Re: State Significant Development Application SSD-80441462 – Waterloo Mixed Use Development, 881–885 Bourke Street, Waterloo

Submitted by: Residents of Morehead Street, Waterloo NSW 2017

MAP ILLUSTRATING VIEWPOINT LOCATIONS

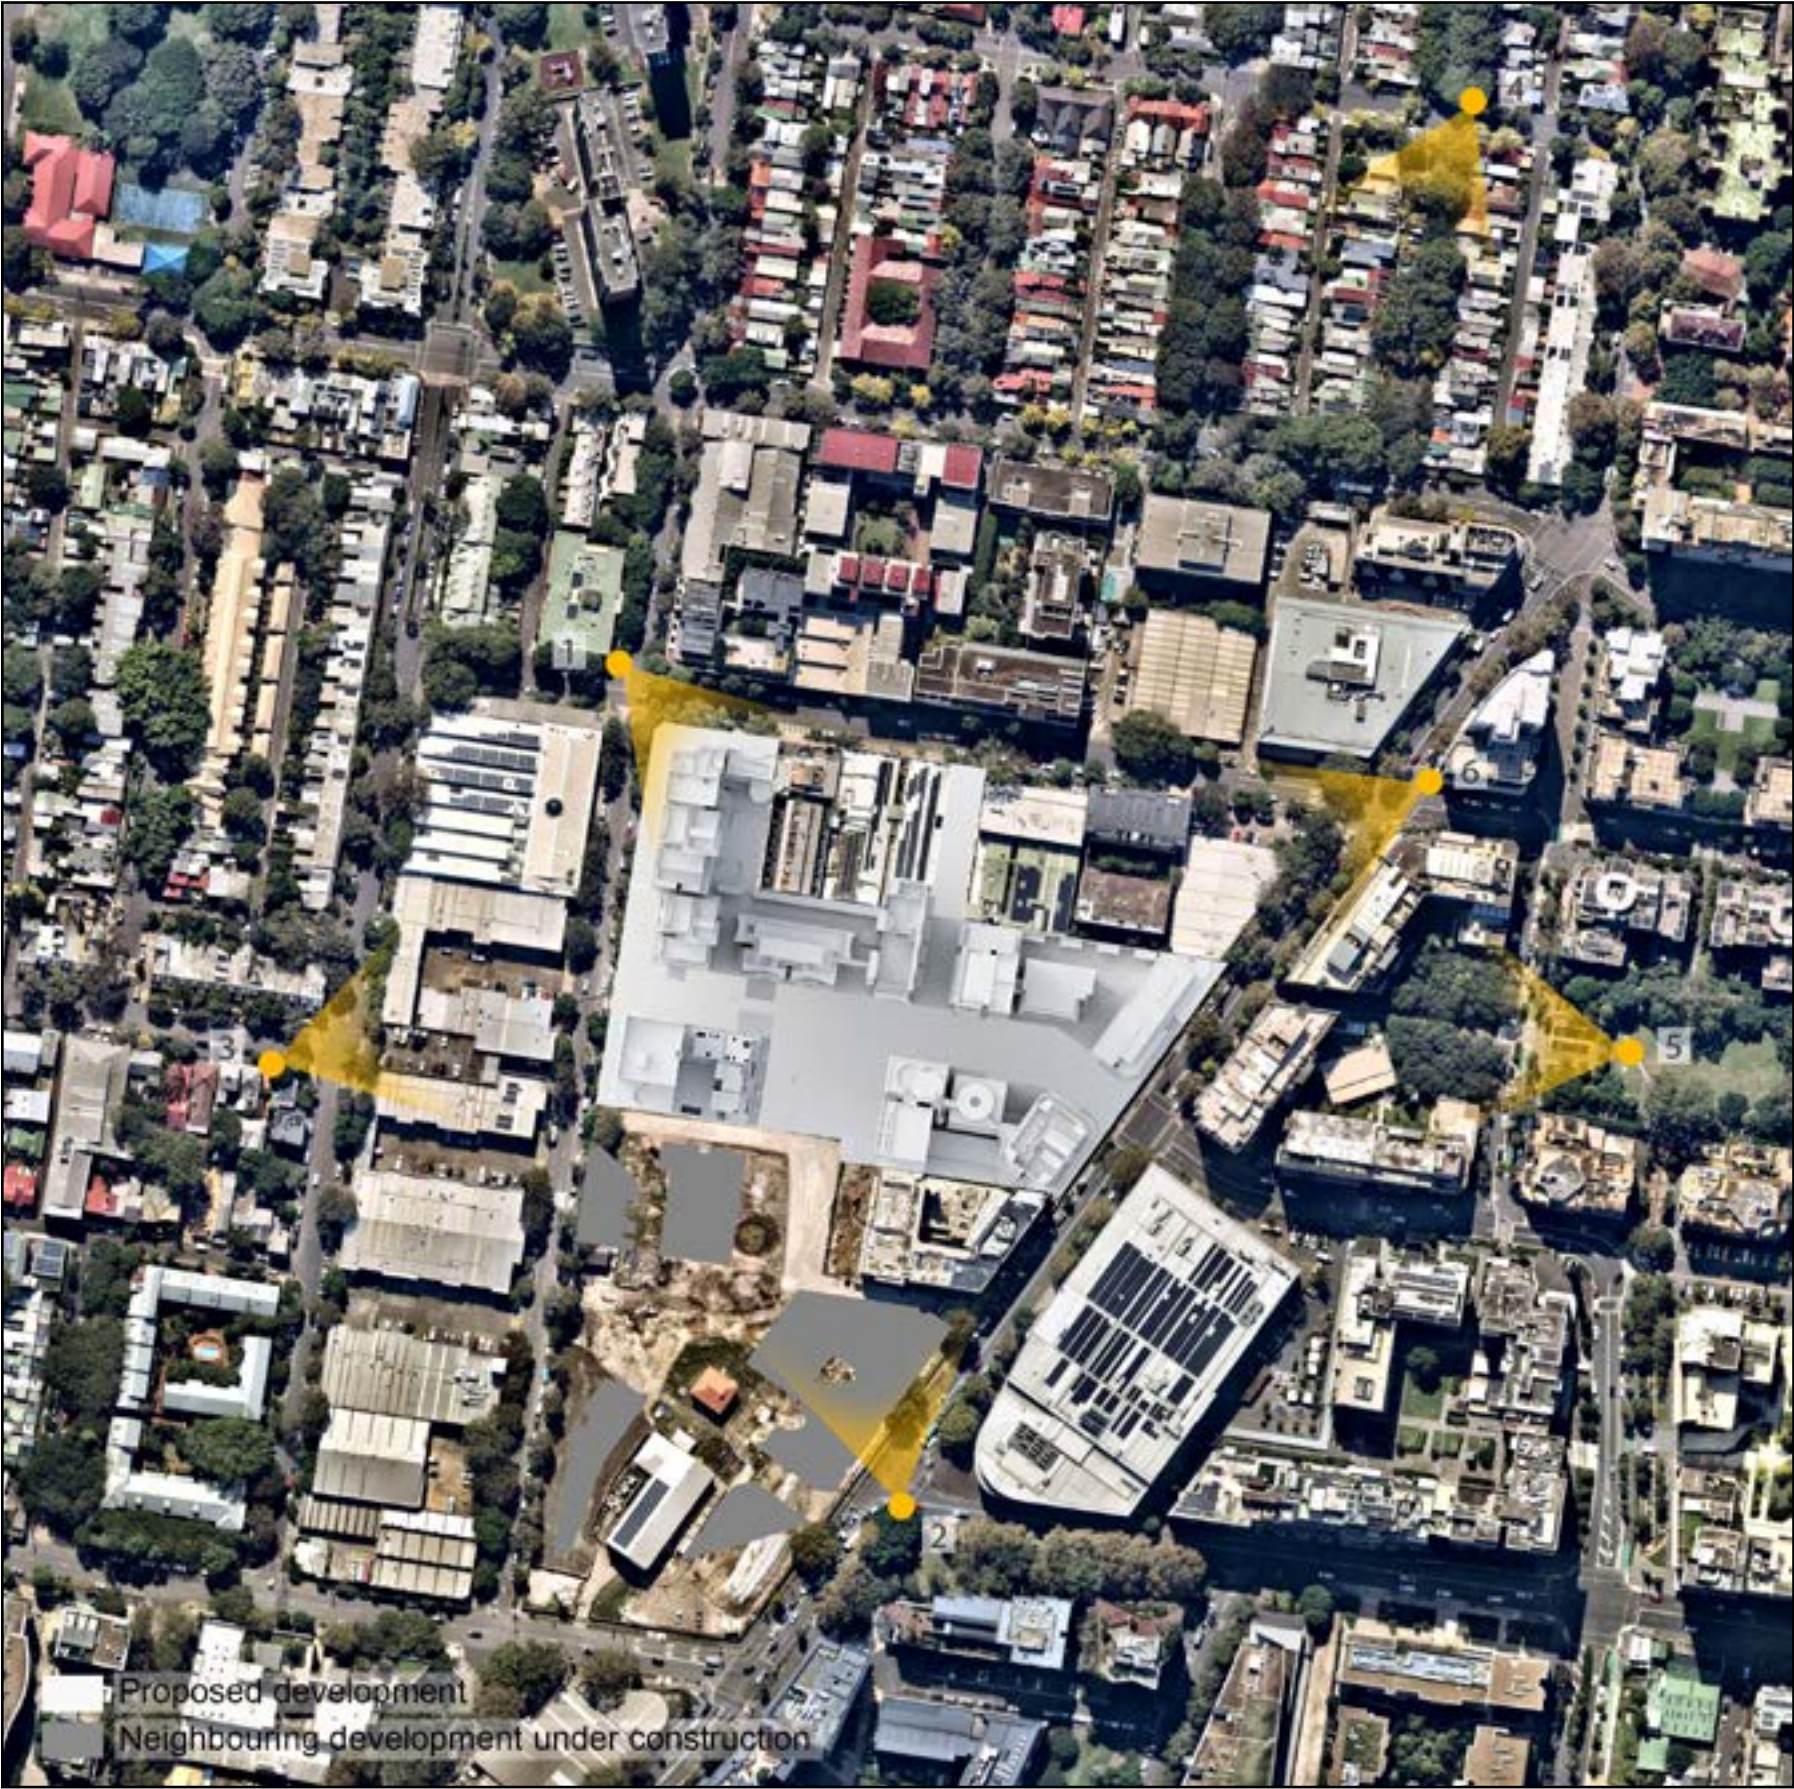
The uplift to **125m**—more than four times the existing 29m control—exceeds any building in the entire Zetland, Waterloo and Green Square area. The VIA acknowledges that the magnitude of visual change is “high”, yet its conclusion of acceptability is flawed due to:

- limited number of and selective chosen viewpoints
- a lack of visual impact study from the Waterloo HCA and listed item Grosvenor Terrace (Morehead St)

The EIS and VIA include **no visual viewpoints** from:

- the Waterloo HCA
- Morehead Street and Grosvenor Terrace (a significant heritage item)

The omission of testing from these locations renders the VIA incomplete and its conclusions unreliable, and contradicts SEARs addressing visual impact, character, and heritage setting.

1. Reduce tower heights and frontages and provide a genuine scale transition to the Waterloo HCA and future residential development between Young and Morehead St.
2. Undertake full visual impact testing from Morehead Street and the Grosvenor Terrace heritage item.
3. Reassess height justification without reliance on Green Square or Lachlan Precinct models.
4. Provide a complete heritage and character impact assessment.
5. Improve the apartment mix to include substantially more family-sized dwellings.
6. Deliver a realistic construction staging plan with clear mitigation measures.
7. Address the procedural fairness issues associated with late notification.
8. Consider extending or re-exhibiting the proposal to ensure public housing residents have a fair opportunity to participate.
